REQUEST

Current Zoning: B-1 (CD) (neighborhood business, conditional)
Proposed Zoning: B-1 (CD) SPA (neighborhood business, conditional, site plan amendment)

Approximately 13.211 acres located along the northern side
Albemarle Rd. between Rocky River Church Road and Blair Road

The petition proposes to amend an existing approved site plan (1998-042C) to permit additional uses including an additional EDEE with accessory drive through and other uses permitted by right and under prescribed conditions in the neighborhood business district.

ERWIN CAPITAL/BEAVER FARMS TECHNICAL DATA SHEET

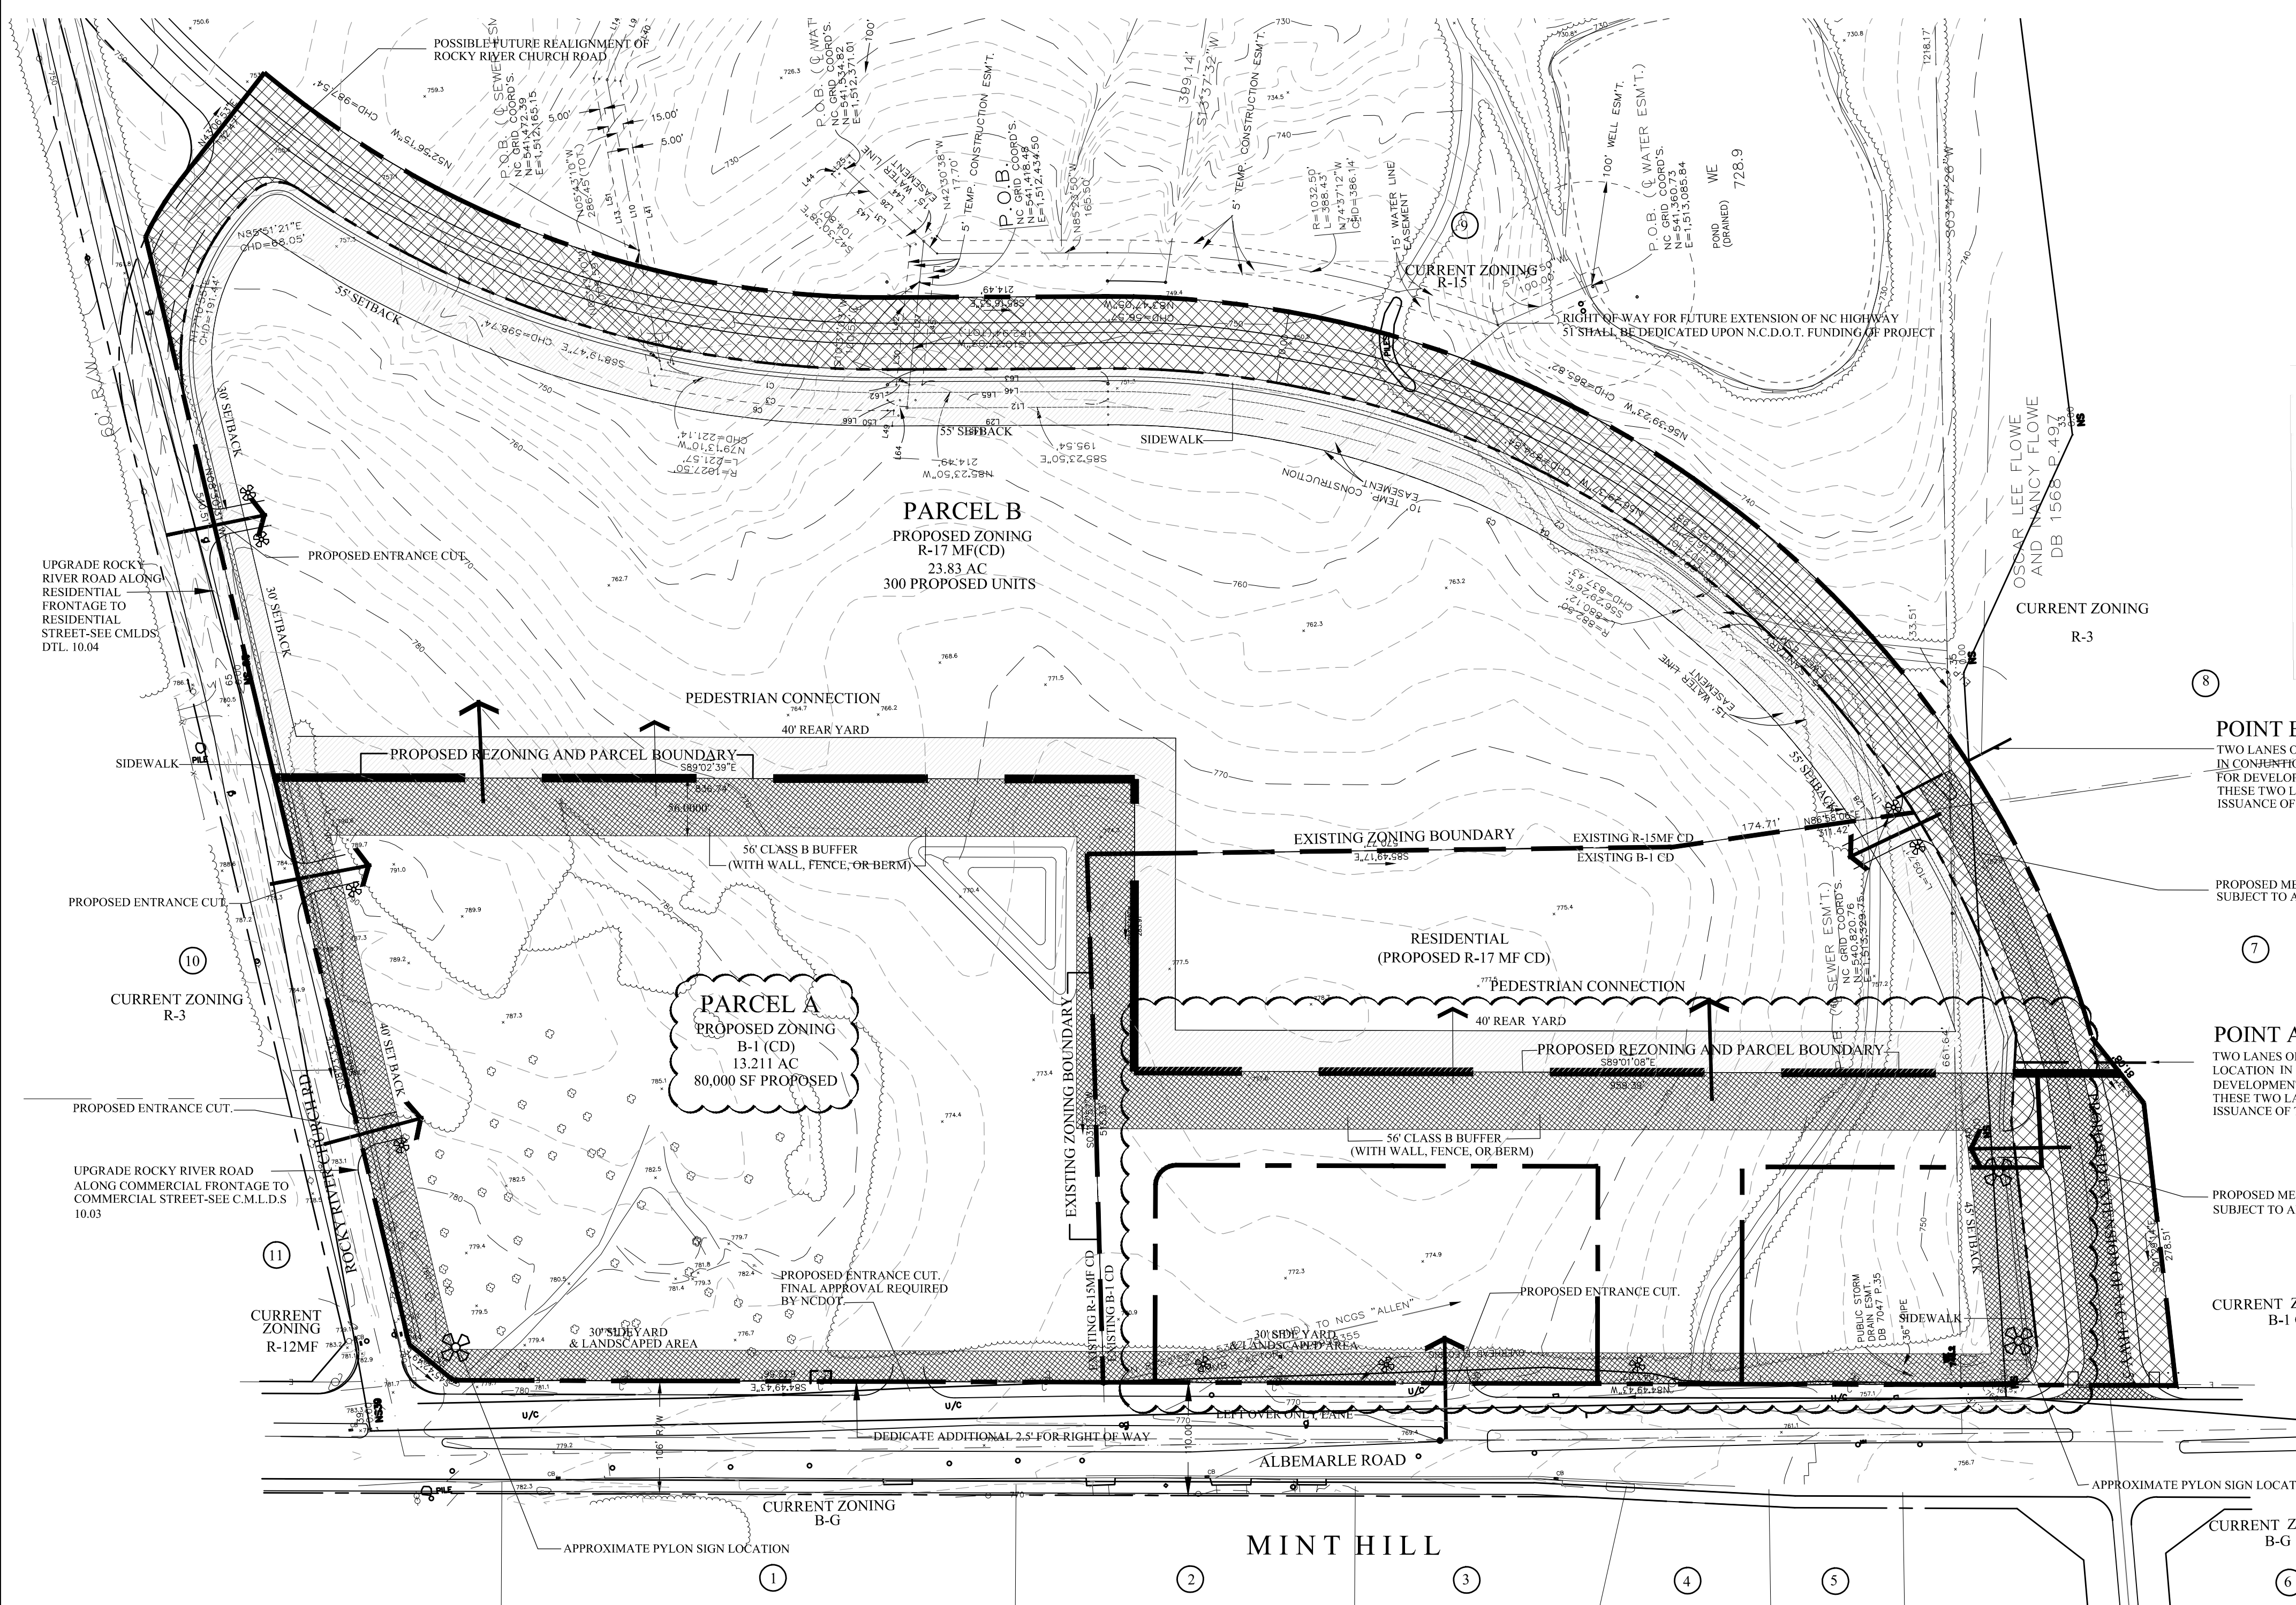
1. ~~The petitioner should revise the site plan and add a note specifying dedication and fee simple conveyance of all rights of way to the City before the site's first building certificate of occupancy is issued. CDOT requests ROW set at 2' behind back of sidewalk where feasible. ADDRESSED~~
Site and Building Design
 2. ~~Revise conditional notes in section F to include hotels as a use subject to the architectural controls listed for non-residential uses. ADDRESSED~~
 3. ~~Revisit language in conditional note F.1.(c) to more precisely describe where/when a building with an accessory drive through window or service lanes/windows may present a circulation drive between the building and adjacent streets. ADDRESSED~~
-
